Our Ref: PAA/171/17/

8th March 2018

Pre-Application Advice

Proposed erection of 27No. Dwellings.
Boweries Barnham Road Eastergate Chichester

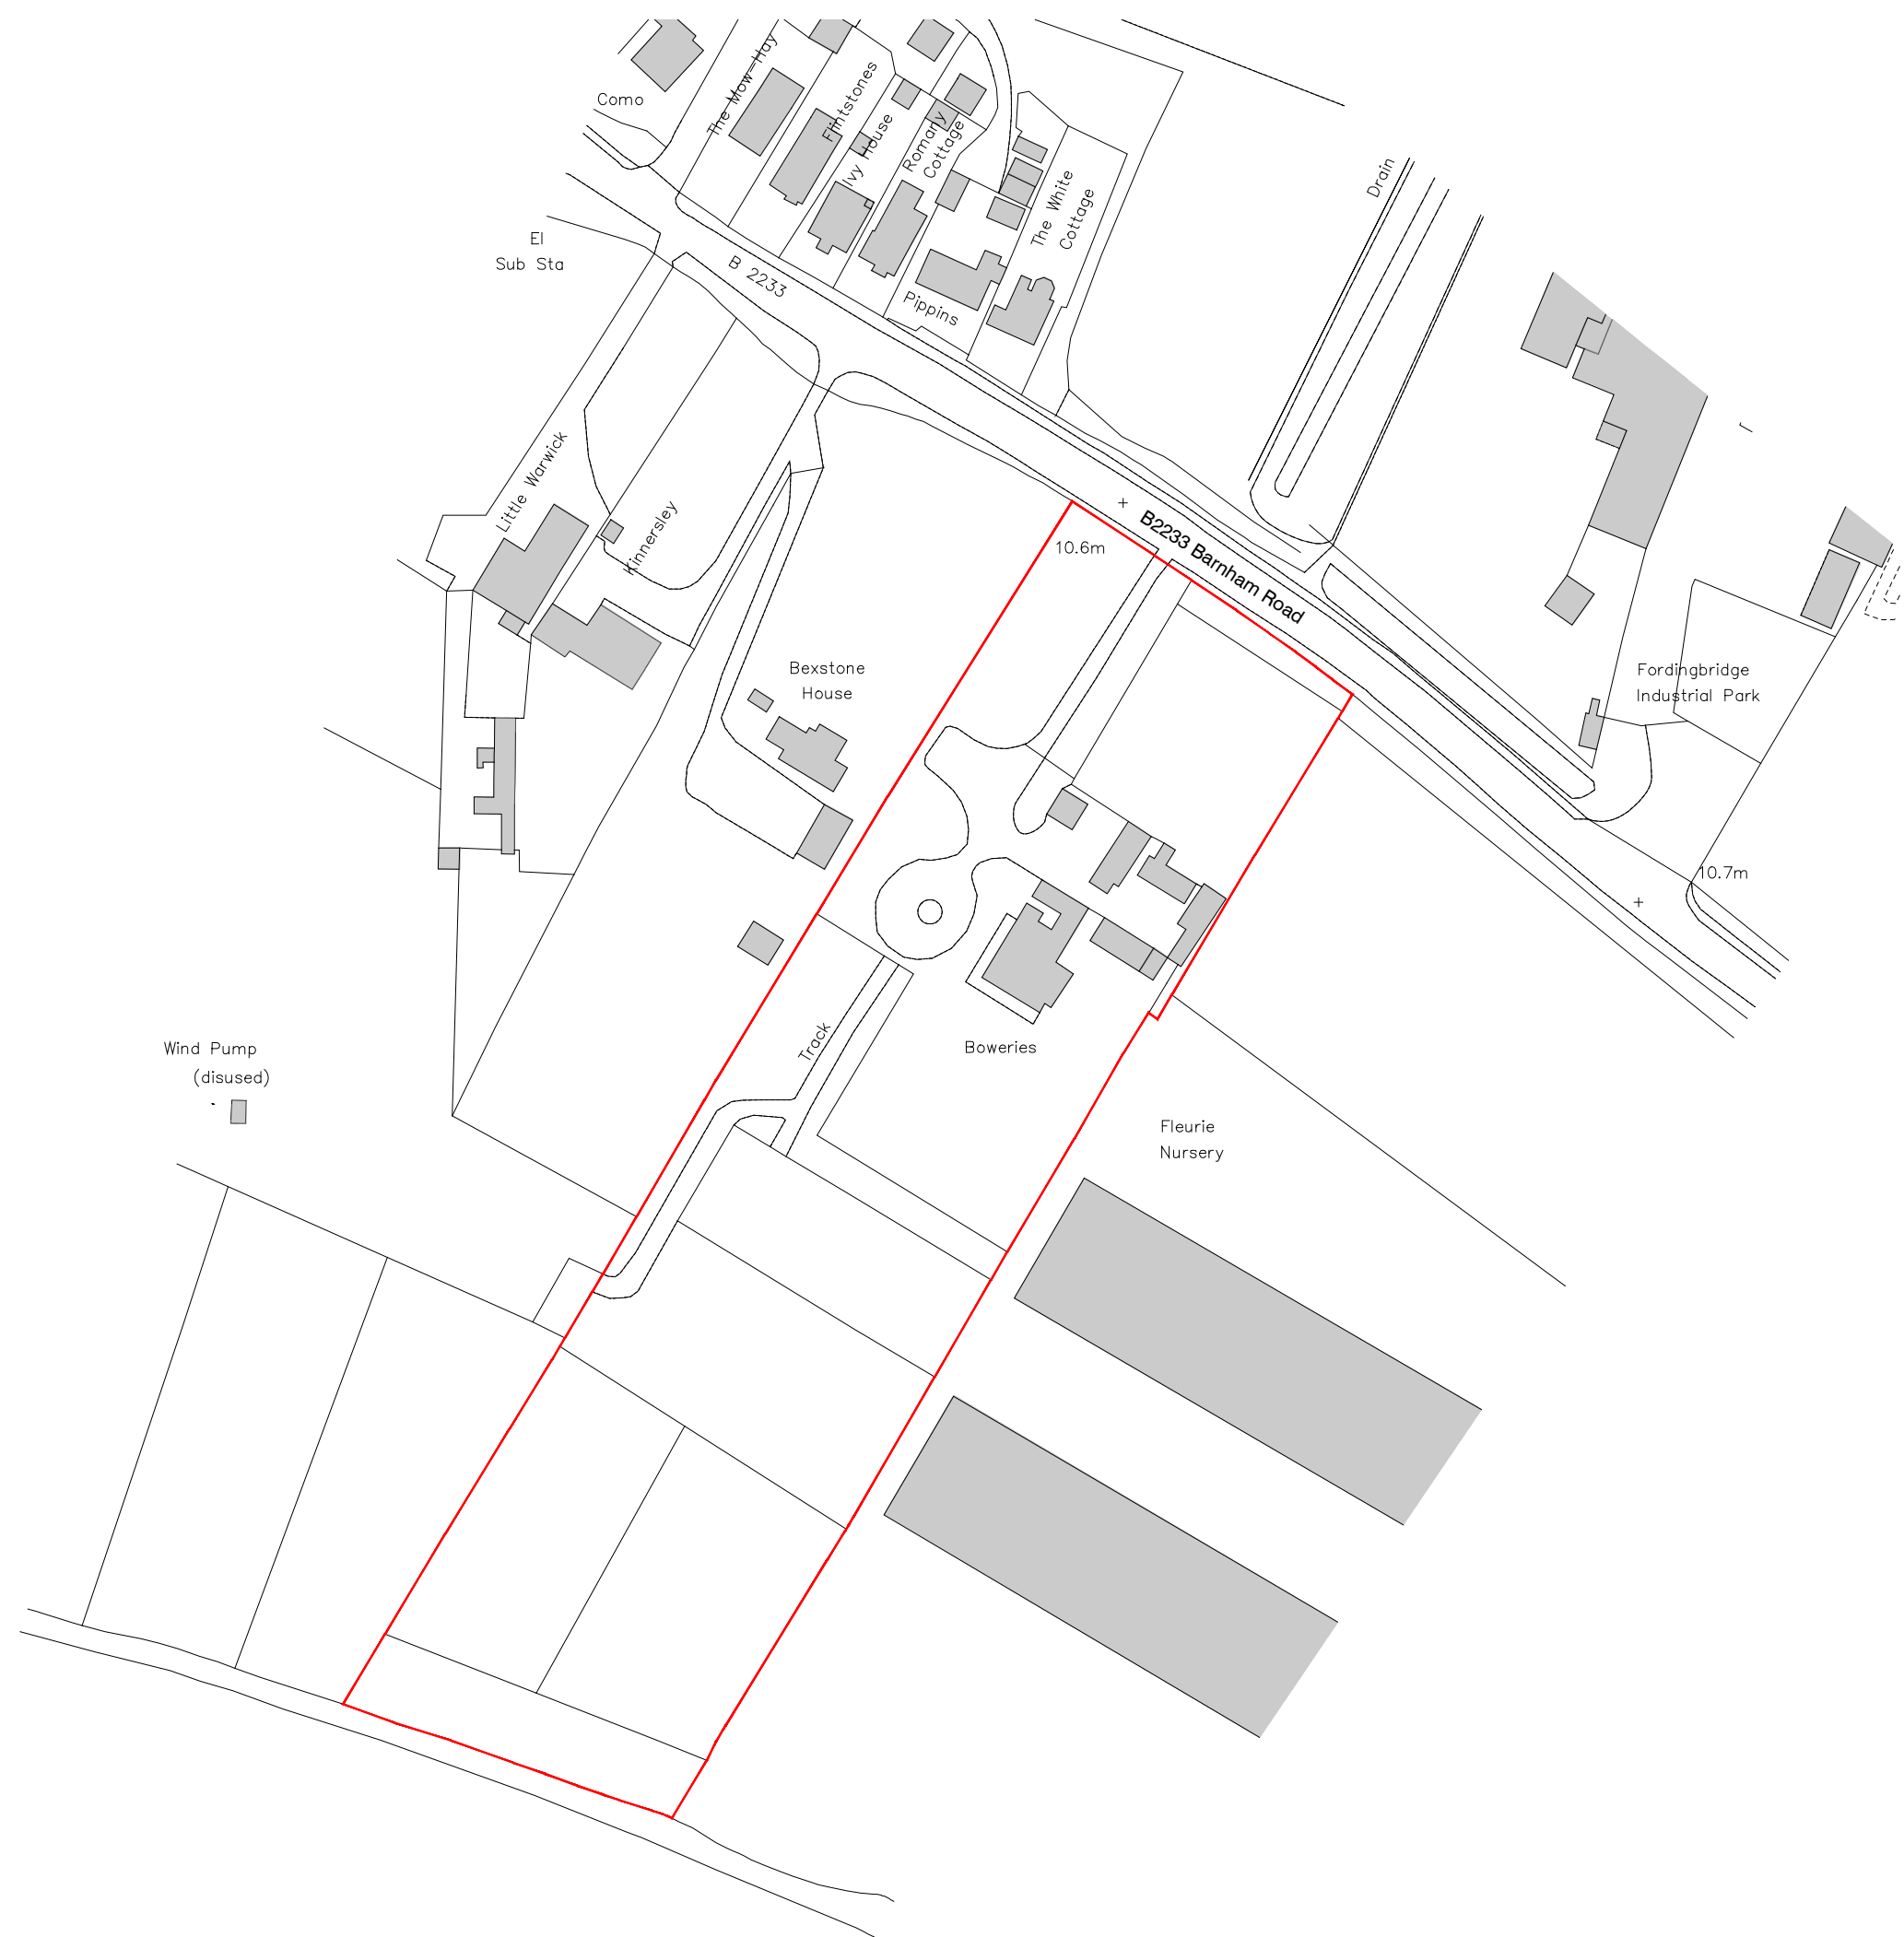
The site is long and narrow which leads to a less than ideal site layout, with properties facing the side fences of other properties and garden fences facing onto the main street. The LEAP is an awkward shaped space to the side of the road. These issues would be overcome and a more acceptable place developed if the site is incorporated into the BEW masterplanning process. This would allow for the site to be designed with adjacent parcels of land, and open up opportunities for designing a successful scheme, rather than a linear cul-de-sac. As set out above, a detailed Masterplan needs to be developed for the site in order to set clear parameters for the design of the site in the context of the allocation.

The proposed development is considered unacceptable by reason of conflict with Policies H SP2 of the eALP in that it has not been comprehensively planned and therefore fails to incorporate a high quality imaginative design which gives a sense of place or permeable layout.

Policy HDQ8 of the BENP requires good quality private amenity space to be provided. Based on the current layout, I would have concerns about the ability to achieve sufficient outdoor private amenity space for some of the plots shown.

We would require confirmation of the areas of public open space being proposed with this development, as a minimum proportionate to the proposed dwellings. As a stand-alone development this would appear to be deficient in open space offer and without masterplan connectivity to adjacent land difficult to assess (stand alone requirement would be for this proposal to provide .20Ha POS, LEAP, LAP and MUGA contribution).
